From: Asa Nilsson-Weber [asaw@iacivil.com]
Sent: Thursday, August 30, 2012 1:46 PM
To: Olson, Greg R.; 'Bryan Bobrick'
Cc: Biazar, Shahab
Subject: RE: C17-D120 Richfield Park Lot 5A -- Responses
Attachments: image001.png; image005.jpg

From: Olson, Greg R. [mailto:grolson@cabq.gov]
Sent: Wednesday, August 29, 2012 10:57 AM
To: AsaW@iacivil.com
Cc: Olson, Greg R.; BryanB@iacivil.com
Subject: C17-D120 Richfield Park Lot 5A "Verbal NO"

Per our phone conversation this AM, the Grading & Drainage plan for this site is generally acceptable, but cannot be approved until the following exceptions are addressed:

GRADING AND DRAINAGE PLAN

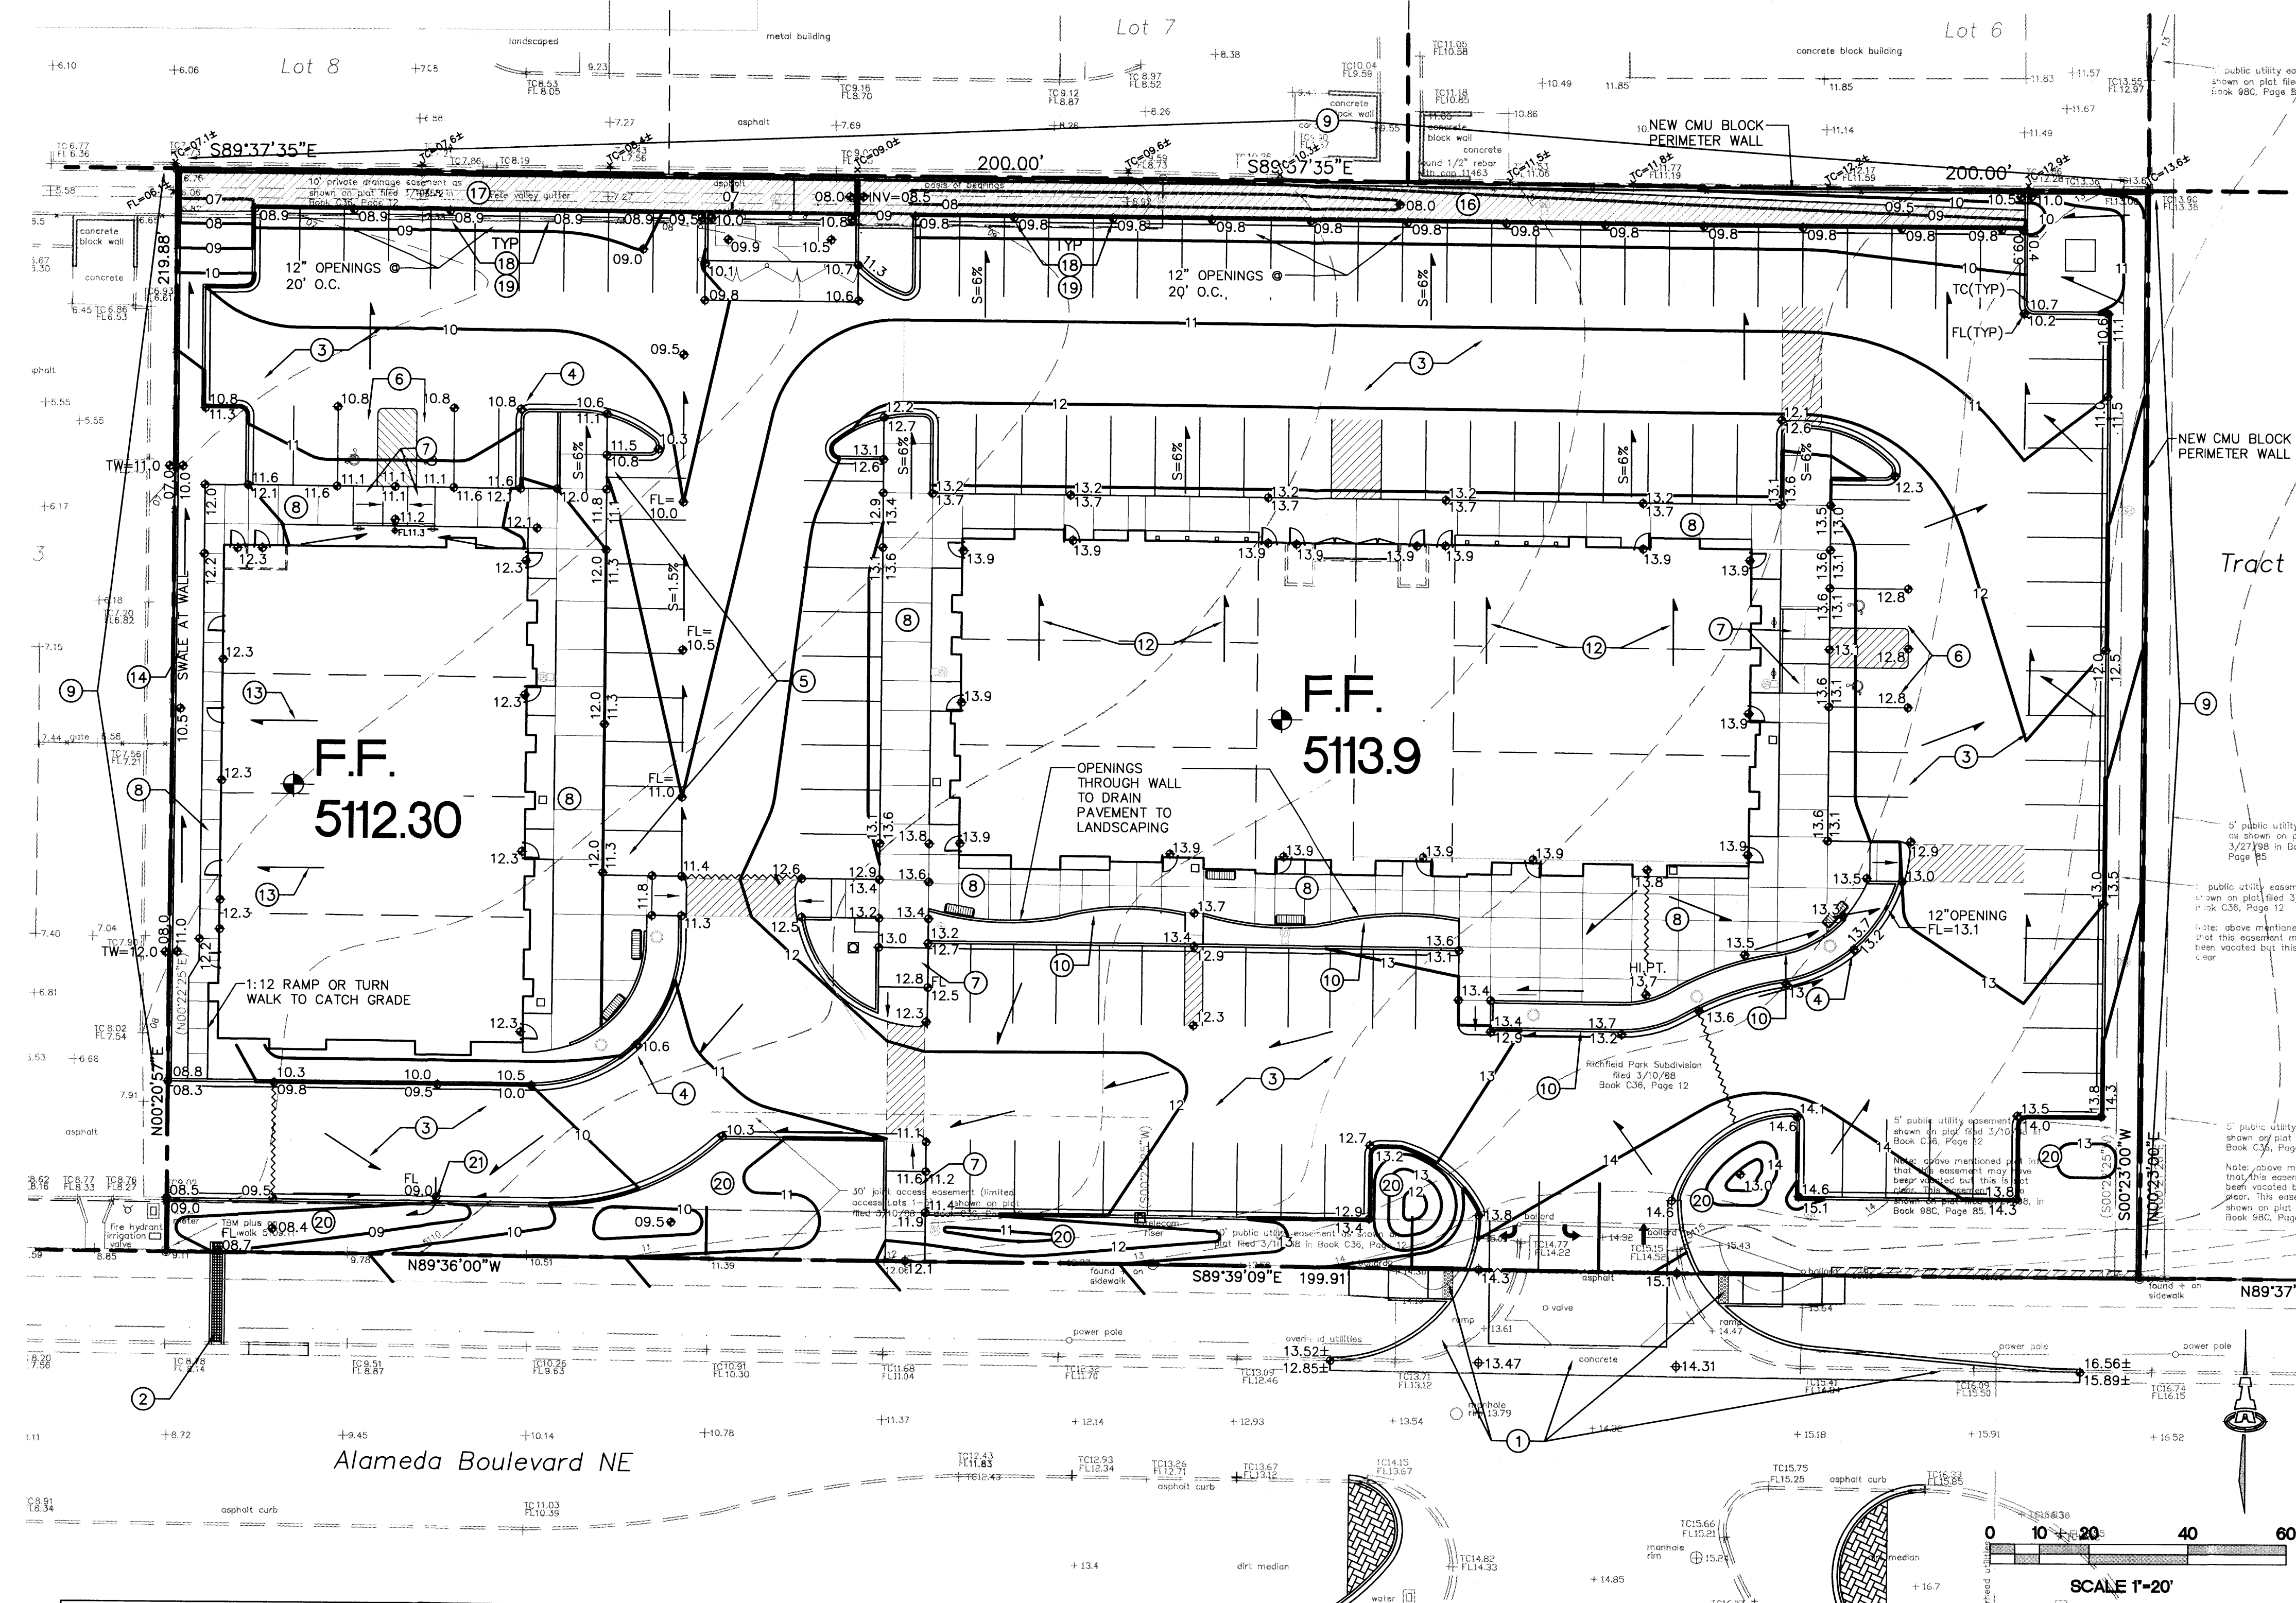
1. The proposed wall on the east boundary appears to block offsite flows from Lot D1A, which may pond behind the wall, or be directed northerly along the property line. Contours shown suggest that these channelized flows (which by the Drainage Master Plan should go to Columbine Road) may cross over into the east side of Lot 6, north of your site. Provide more detail as to how these offsite flows will be routed after construction of the wall. If offsite grading is required to deal with this situation, we will require written permission from the owners of the offsite parcel(s).

2. Address drafting details on the plans as follows:
 - a. Sh. CG-101: Key Note 2 should include a width for the Sidewalk Culvert.
 - b. Sh. CG-101: Provide Flow arrows in the swale along the west side of the lot.

- c. Sh. CG-101: Call out a curb opening and width at the low point in the driving lane south curb approx. 60' ENE of the SW corner of the site (at El. 9.0).

Here are some additional photos that will help show that the proposed wall is not changing the existing flow pattern. As part of the recent milling overlay, the property owner to the east graded a defined berm transitioning to a swale at the northwest corner of his property. This was probably done to prevent "developed" flow from passing onto our client's property.

Because the adjacent property has been partially developed and graded to deflect flows to the north per the master drainage plan, the proposed wall at the east side of our site should not be considered as deflecting historic offsite flow. We believe that since the historic flow pattern has been altered by the adjacent development, the adjacent property owner is responsible for that flow and how it is routed per the master drainage plan.

1. No offsite flow passes to the property from the east. The photo below shows the east property graded with asphalt millings to serve as an overflow parking area (by others). A deflection berm at the joint property line deflects sheetflow to the north to follow the required drainage path for Parcel C1-D. In addition, a perimeter wall proposed as part of the Lot 5A construction which will also serve to deflect offsite flow.

The existing topo contours show a minor slope from south to north. The photo shows a small deflection berm. In addition, I have discussed the concern with John Mechenbier and he has agreed to waterproof the bottom rows of blocks. Will this suffice?

HEADWALL A: BETWEEN PONDS 1 AND 2

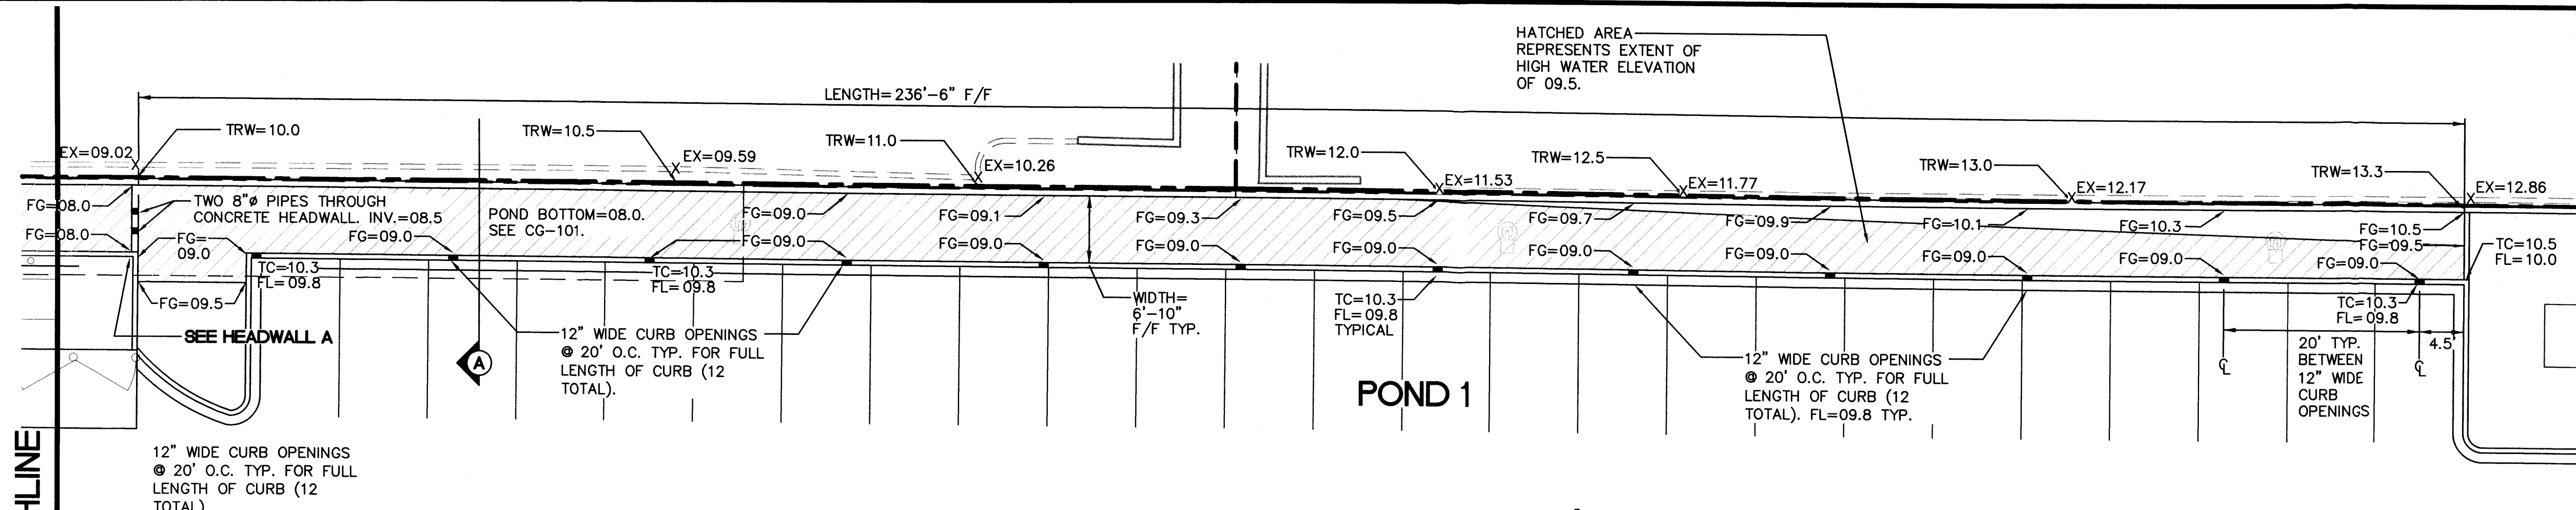
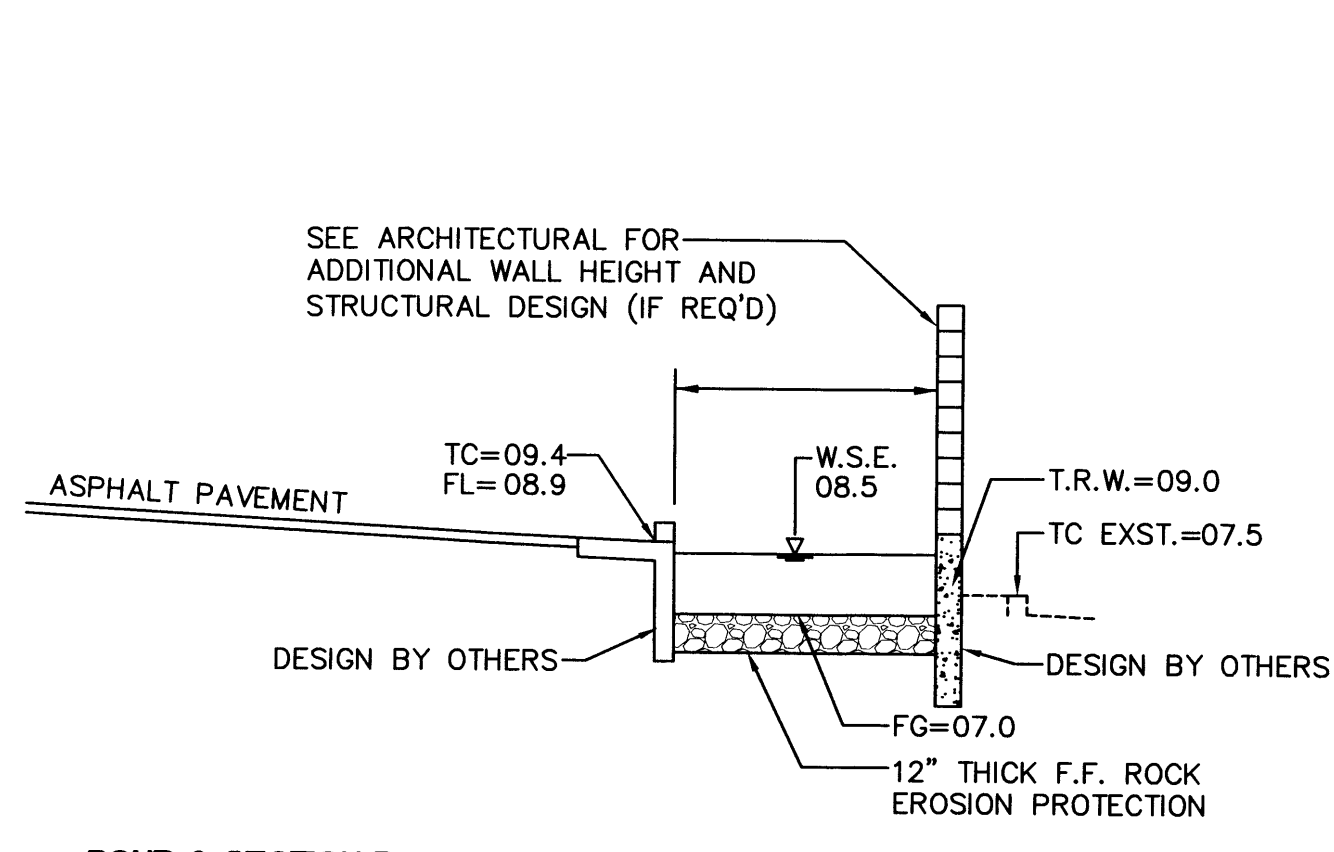
- d. Sh. CG-501: The lower of the two Headwall A Details appears to represent Headwall B.
Please clarify/re-label.
